City of Albuquerque Stormwater Construction Site Inspection Report

Project Name:	Springhill Suites				
Location:	1101 Central				
Site Contact Name & Agency	Jeff Harper jeff.harper@jaynescorp.com	ESC File No.	K15E034B		
		NPDES Id. No.	NMR1001RP		
Inspection Date:	05/07/19	Start/End Time:	1415/1430hrs		
CoA Stormwater Inspector:	Timothy E. Sims				
Construction Phase:	vertical with site work				
Type of Inspection:	<input type="checkbox"/> Regular	<input type="checkbox"/> Storm Event	<input type="checkbox"/> Post Storm Event >0.25"	<input checked="" type="checkbox"/> 311/Complaint	<input type="checkbox"/> Follow Up

ES-102

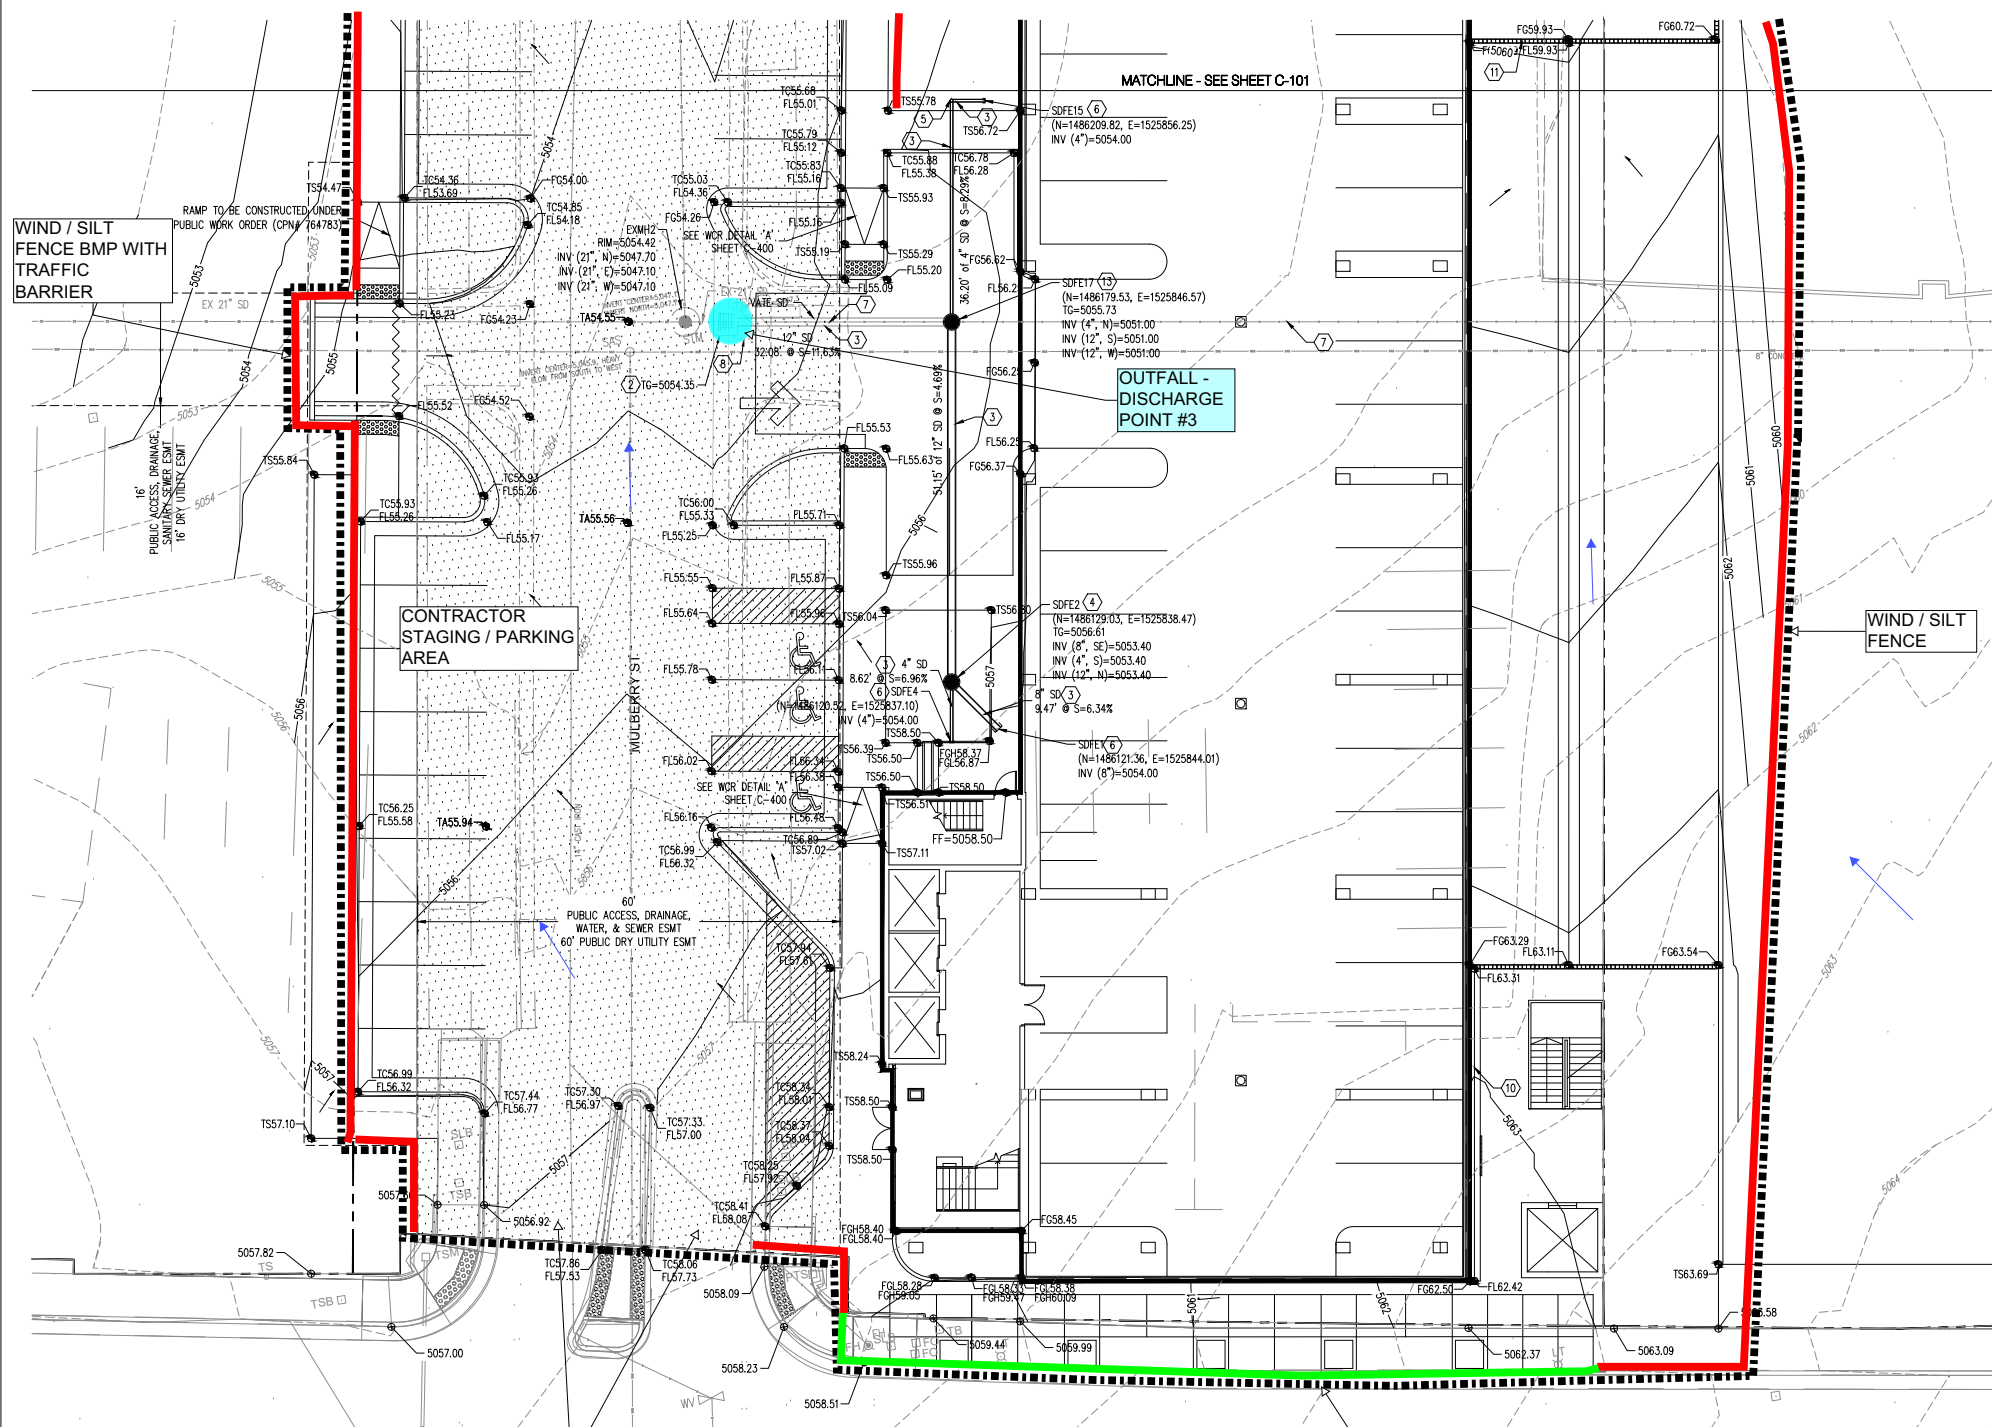
Item Number	Deficiency/ Corrective Action			
1	Washout south of concrete washout facility			
2	Washout south west corner of building			
3	Domestic waste not in acceptable container- water bottles			
2.1	Discharge off site? (Y/N)	No		
4	Self Inspection Reports		Latest report Date:	4/30/2019

Notes:	Jeff did notice the northeastern most access point off of Cedar will require a trackout pad.
